App: Y/157/21/DOC

Proposal: Approval of details reserved by condition imposed under Y/146/20/RES relating to conditions 3-cycle spaces & 7-external lighting.

Address: Land at Street Buildings North End Road Yapton BN18 0DT

Condition 7

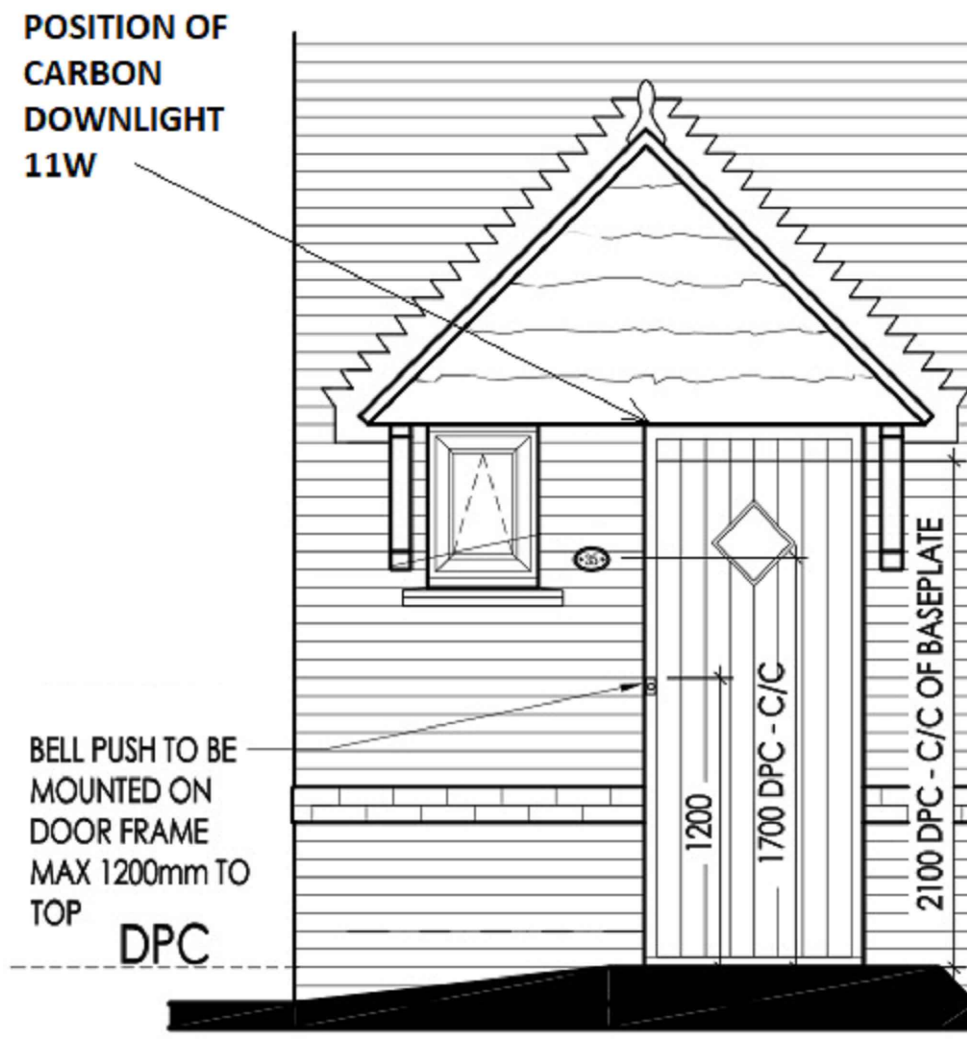
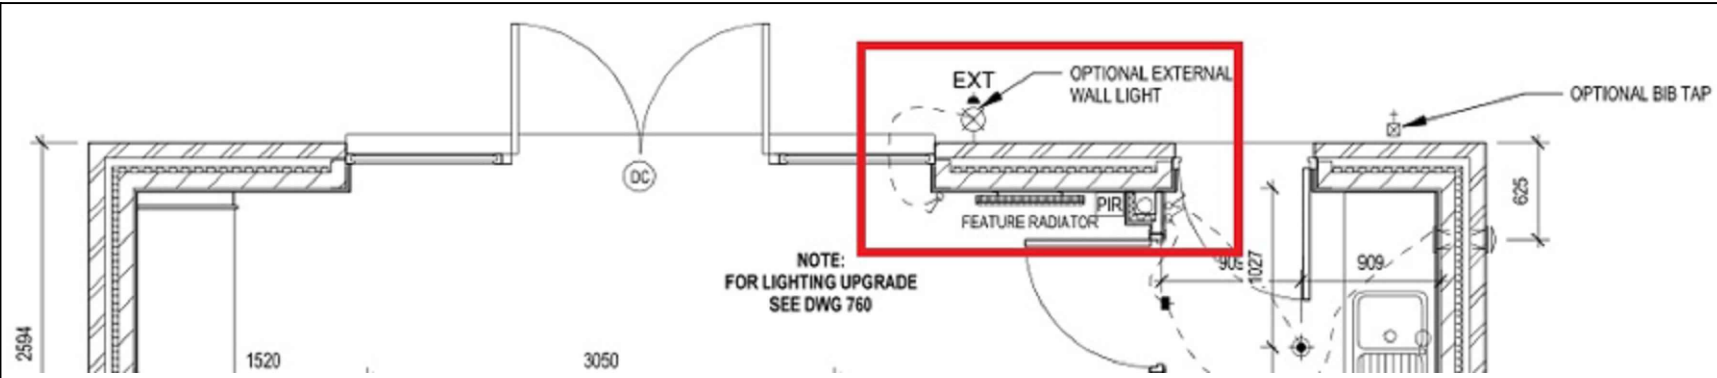
We are satisfied the lighting scheme for this site follows best practice to reduce lighting spill to onto boundary habitats by utilising light shields and warm white spectrum lanterns.
